Subject: Request for Comment on Cabramatta Rail Loop – extended exhibition period (SSI 9186)

EES has reviewed the response to submissions prepared by ARTC undated and provide the following comments:

Appendix B – Post Development Flood Maps

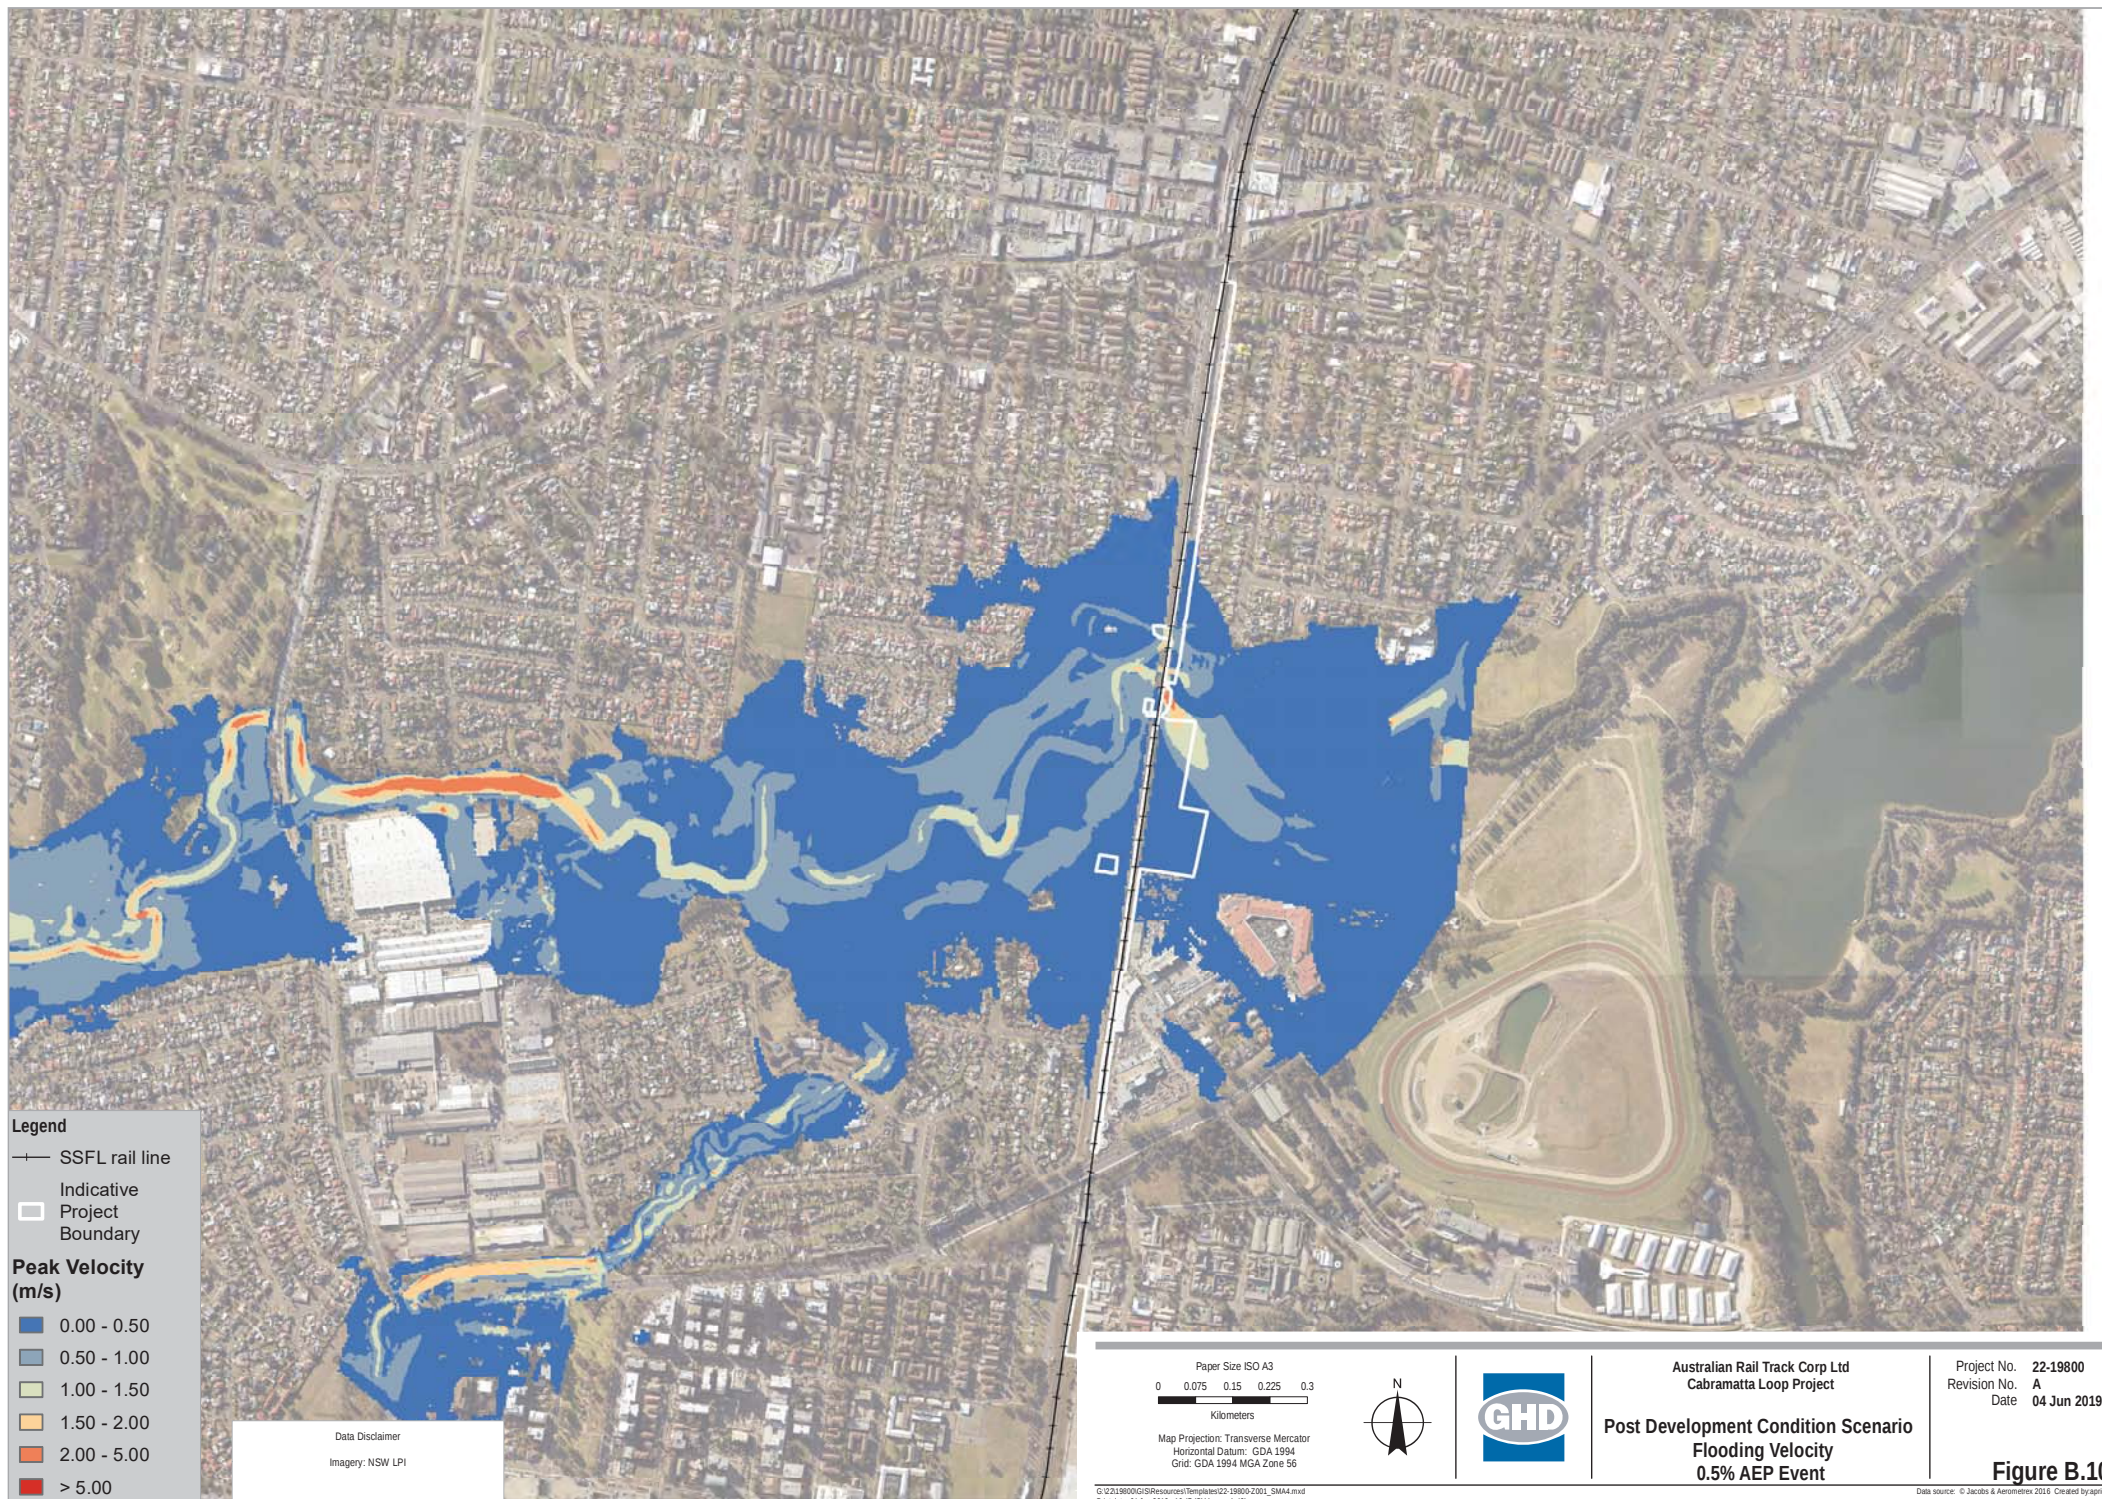
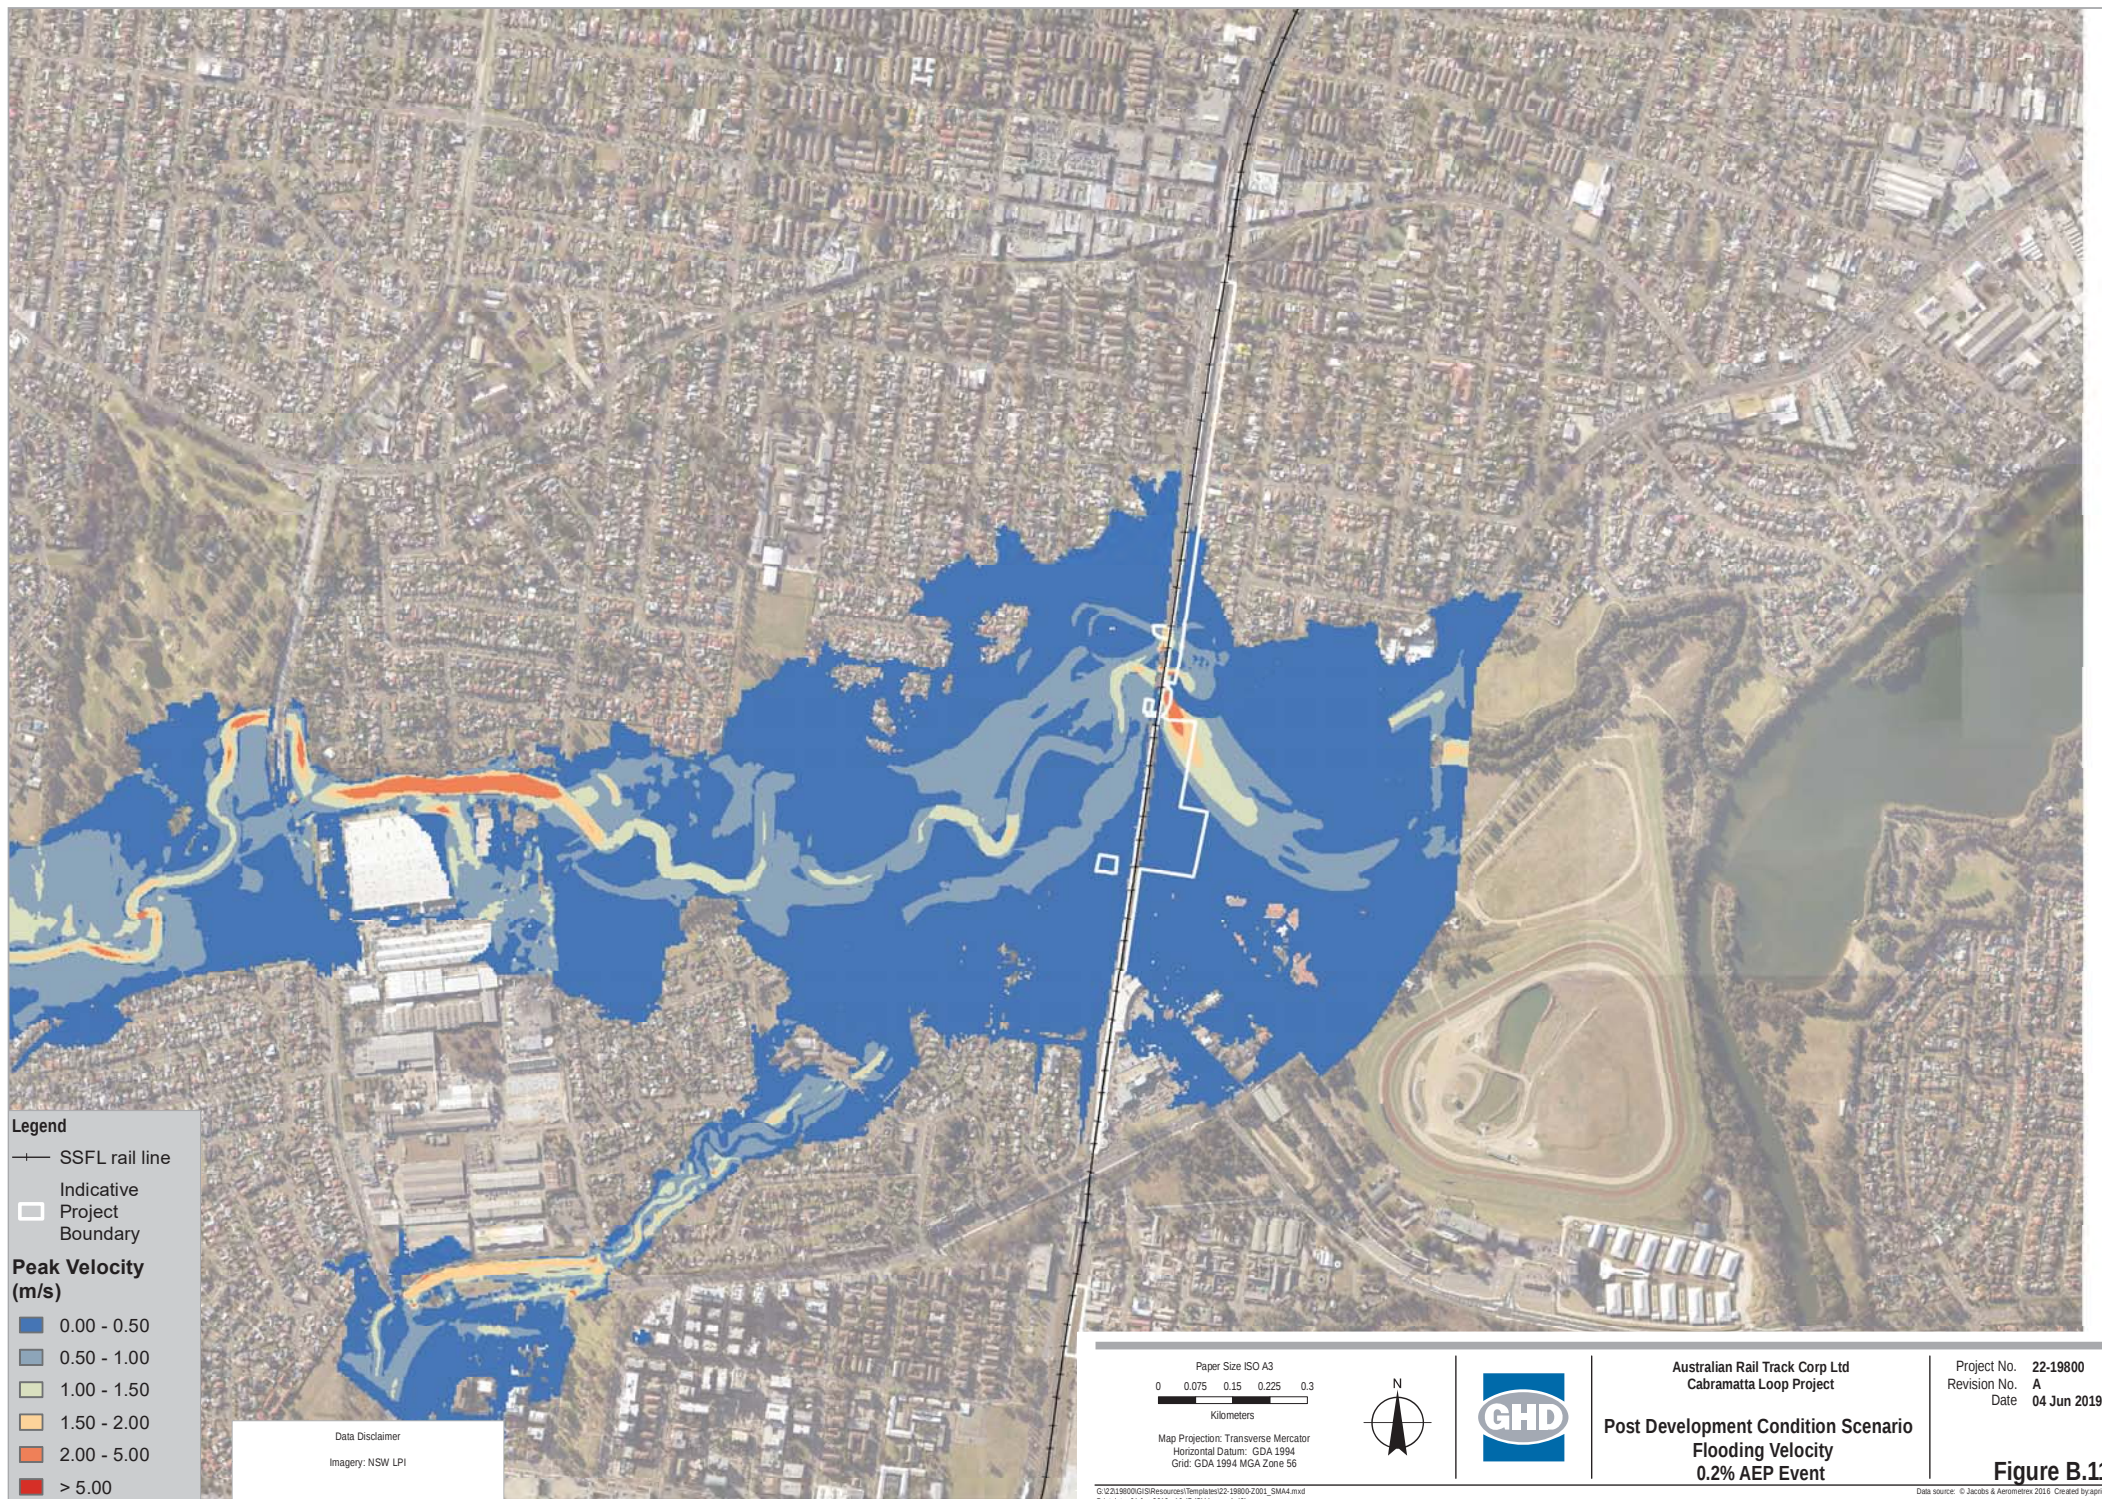
The modelling results indicate that some pockets of the existing catchment (especially properties along Bloomfield Street) are likely to be impacted by flooding under the post construction and operational stage of rail infrastructure. The adopted criteria (Table 4.3 of Technical Report 5) for the change in flood levels have been exceeded within the boundary of impacted properties. The proponent will use 690m³ of fill for the realignment of Bloomfield Street to accommodate the proposed loop rail.

The assessment of flooding risks under baseline conditions and the post construction stage has been undertaken by using a normal depth boundary relationship at the outlet of Bloomfield Street Catchment (Section 2.3 of Bloomfield Street Flood Study Assessment). This may underestimate the flooding conditions and inundation depths within the Bloomfield Street Catchment since the intersection of Bloomfield and Sussex Streets is approximately 100m from Cabramatta Creek and is expected to be submerged under a 5% AEP event. The assessment should also be made considering QH (rating table) or HT (time variant water level) boundary conditions at the outlet of Bloomfield Street Catchment to evaluate flooding conditions and develop appropriate flood mitigation measures under post construction and operational stage of the proposed infrastructure.
